Post Submission Additional Documents (No 24/00246/P, No 24/00245/LBC, No 24/00243/P and No 24/00244/LBC)

Manse

Ruin

PROPOSED CHURCH ROOF PLAN

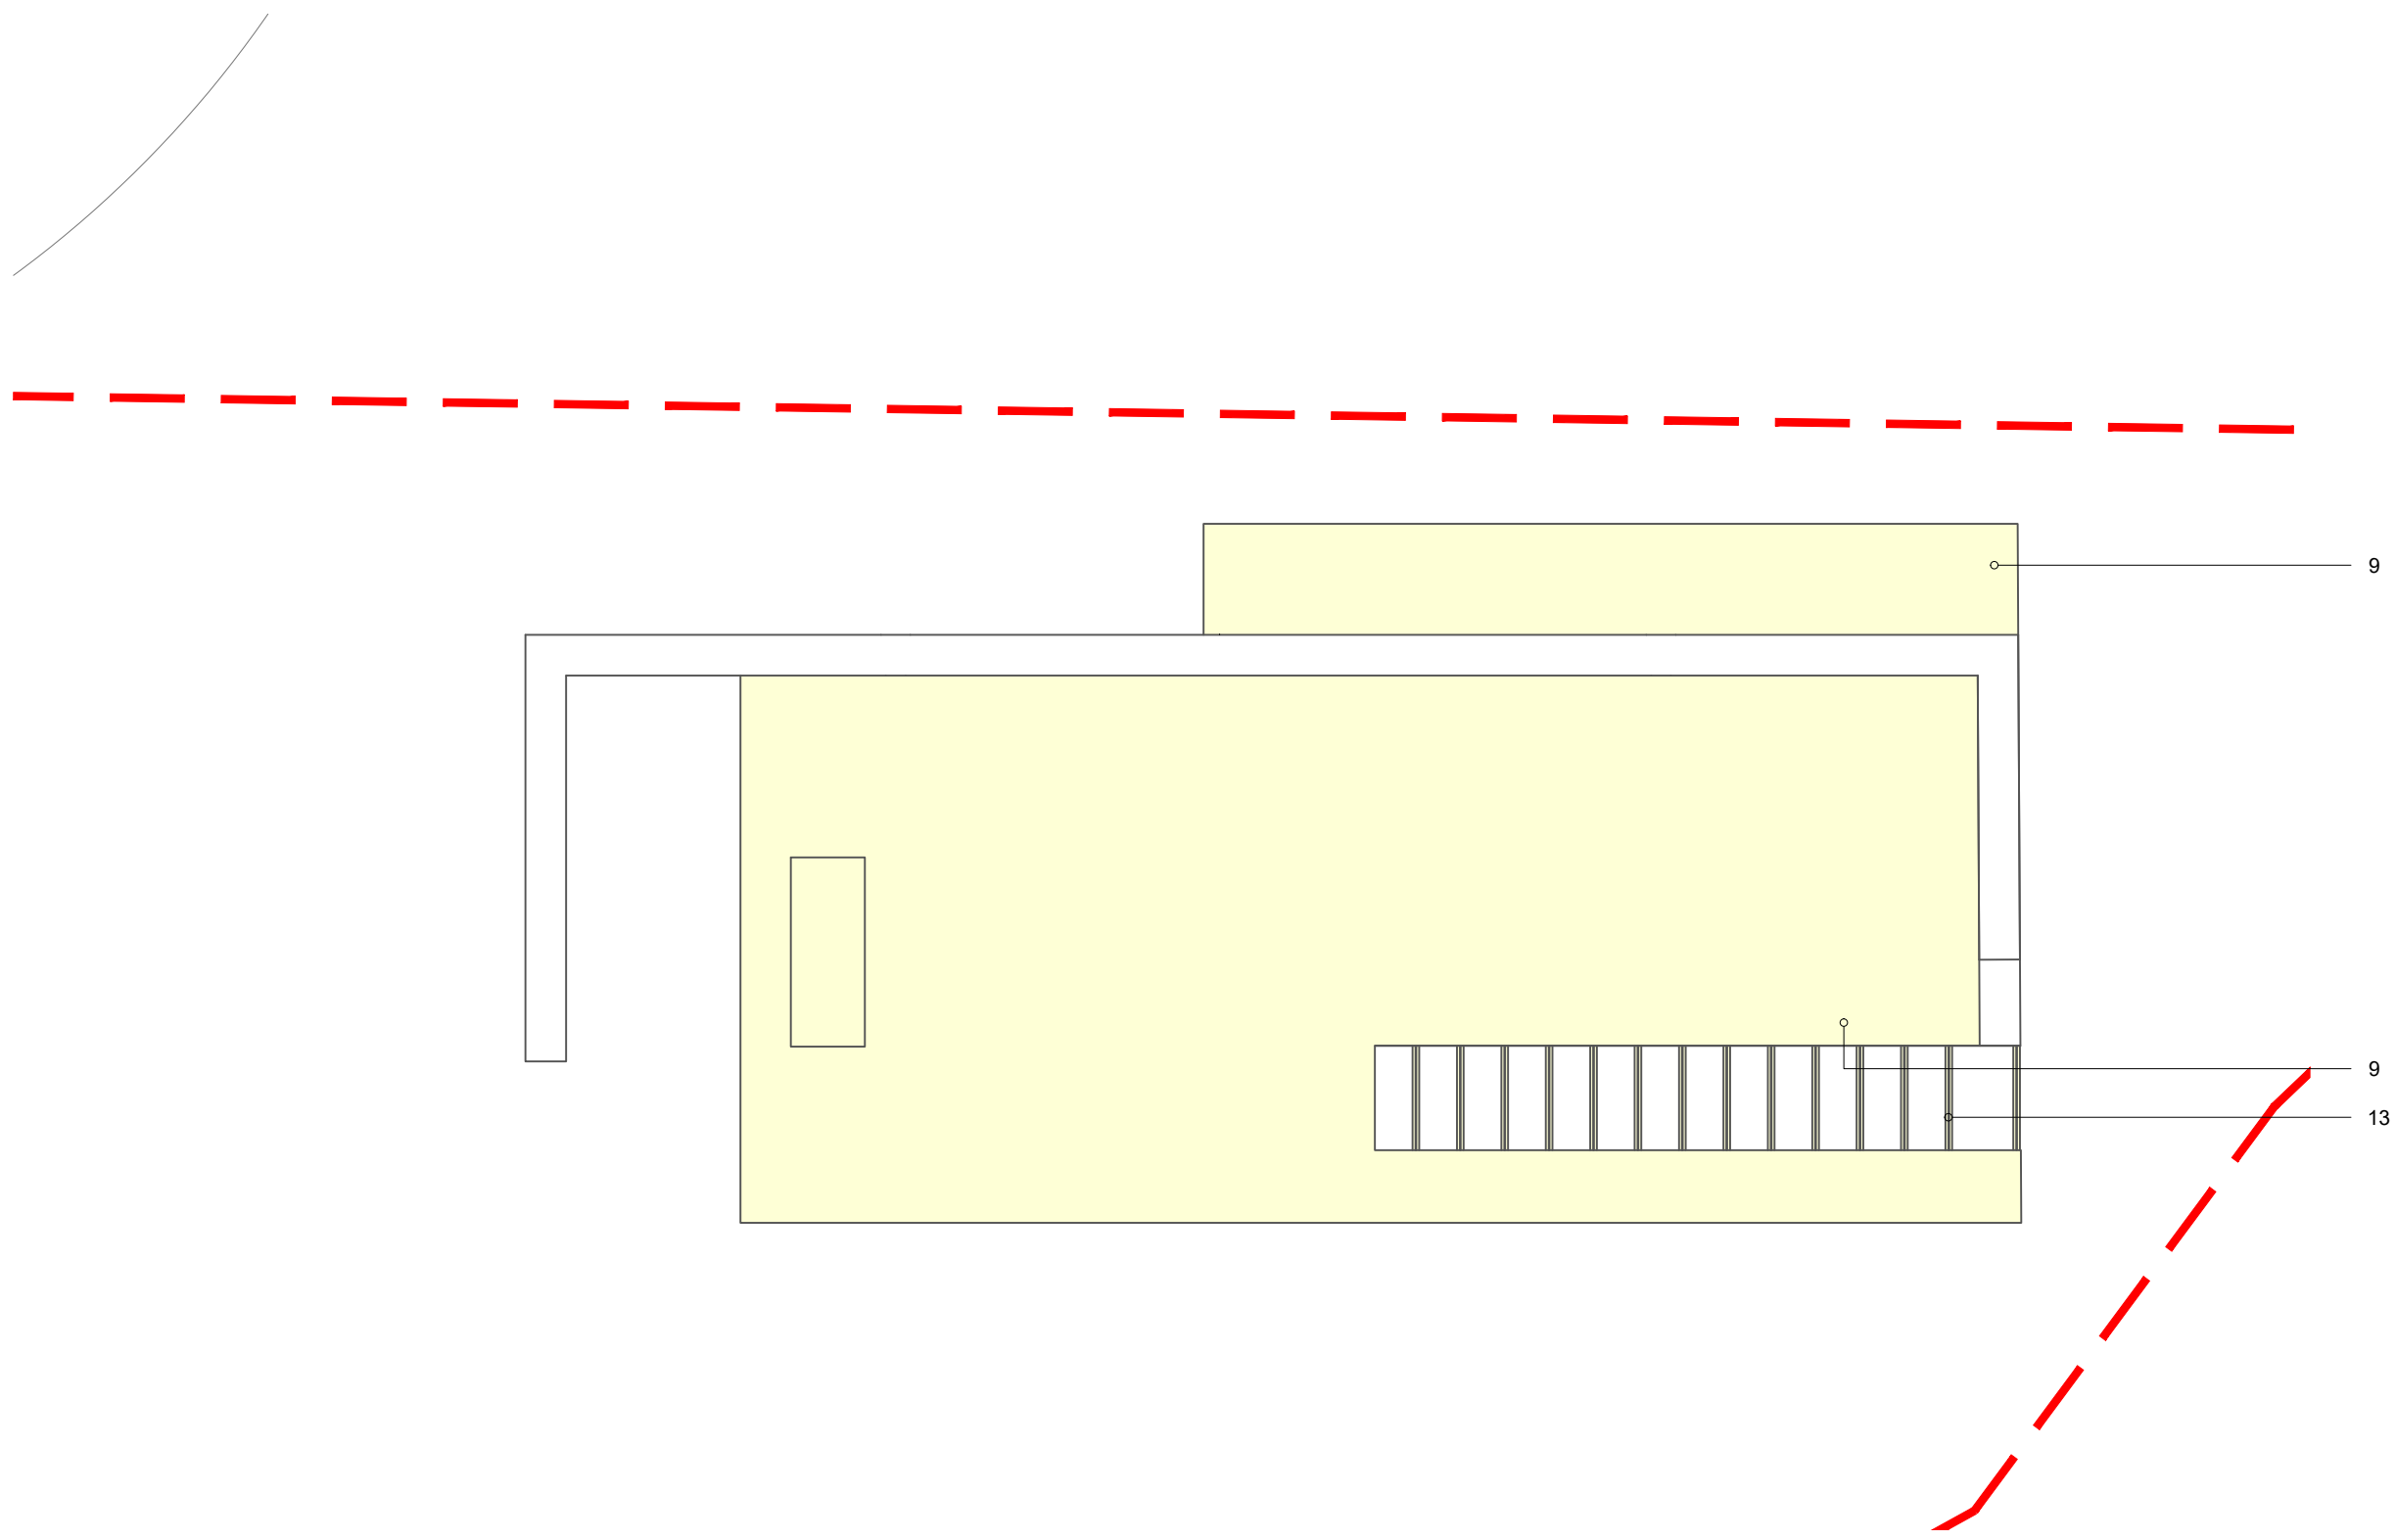
- Air source heat pump hatching added on plan
- Existing photos of ruin separated into separate drawing
- Notes and hatching updated to open pergola roof on ruin (please note this is not a roof light)
- Notes and hatching updated to reflect abutting paving (new paving will touch existing buildings in both applications)
